## Application by Rosefield Energyfarm Limited for the Rosefield Solar Farm

The Examining Authority's first written questions and requests for information (ExQ1): issued on 2 April 2026

TITLE:
 FIGURE 1.1 LOCATION PLAN

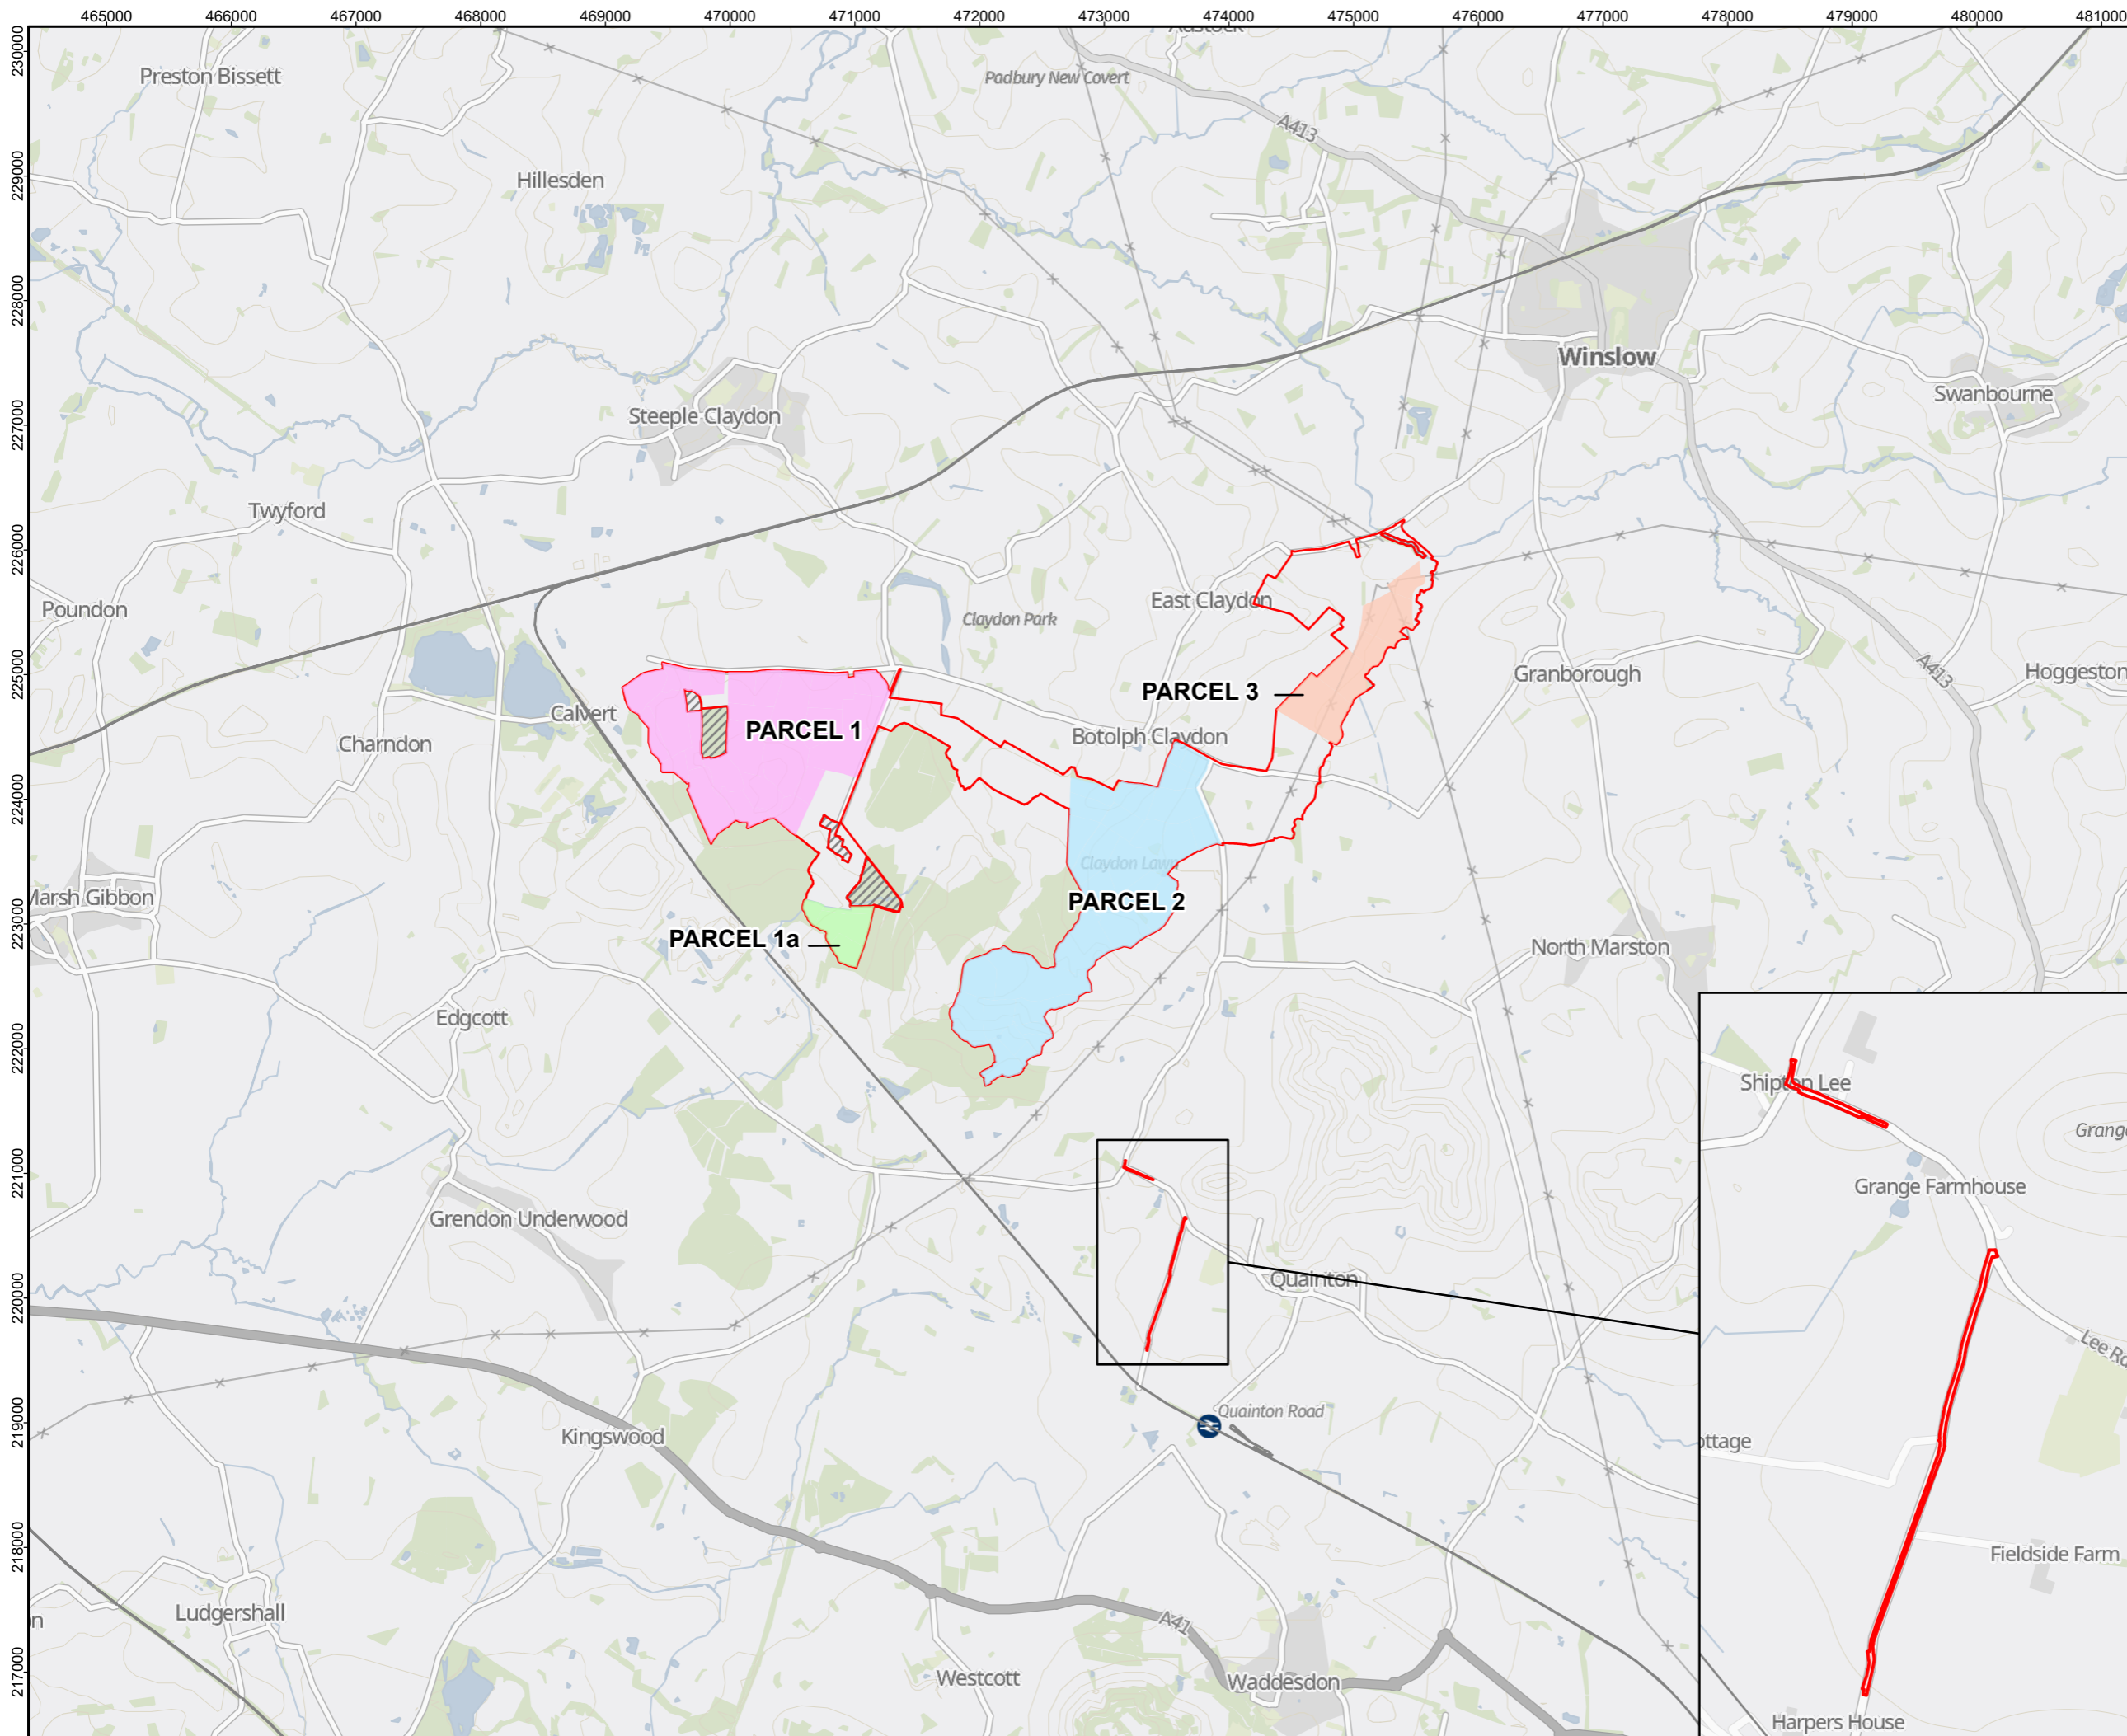
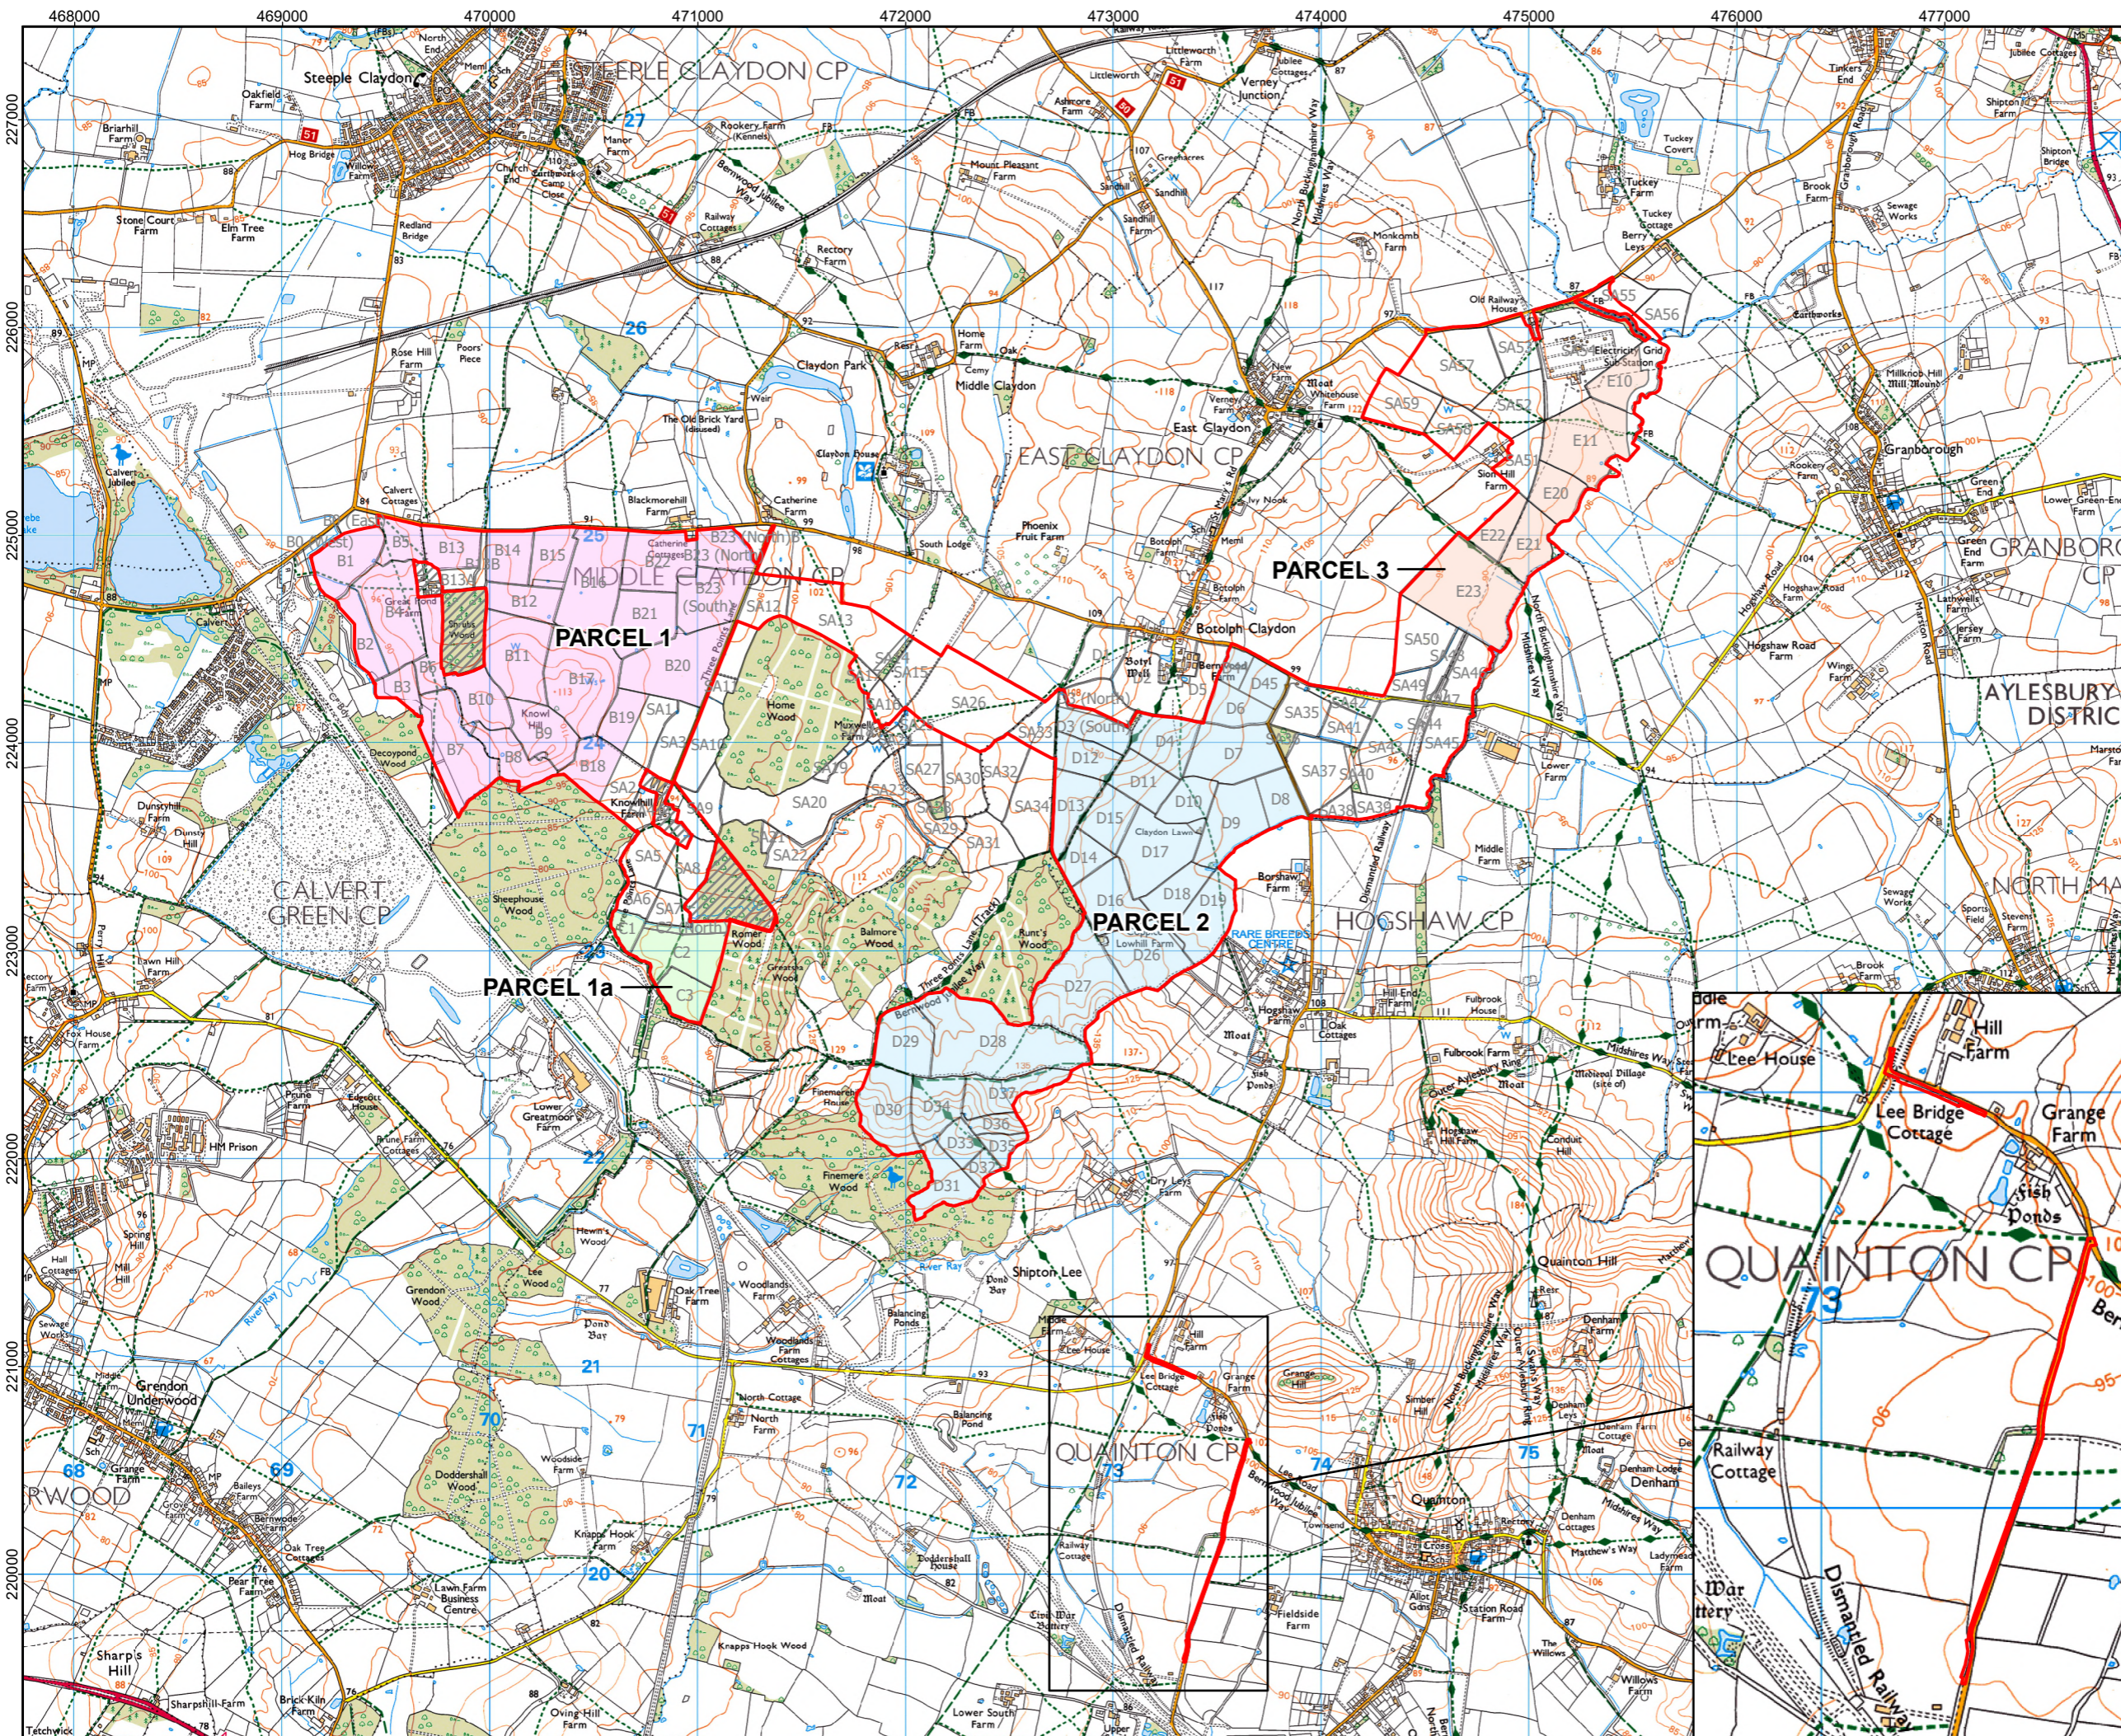
| ExQ1   | Question to:                                  | Question:   |
|--|---|---|
| Q1.1.2   | The applicant                                 | <p><b>Plans</b></p> <p>Update Environmental Statement Background and Context Figures, Figure 1.1 Location Plan [APP-061] to identify land parcels 1, 1a, 2 and 3.</p>   |
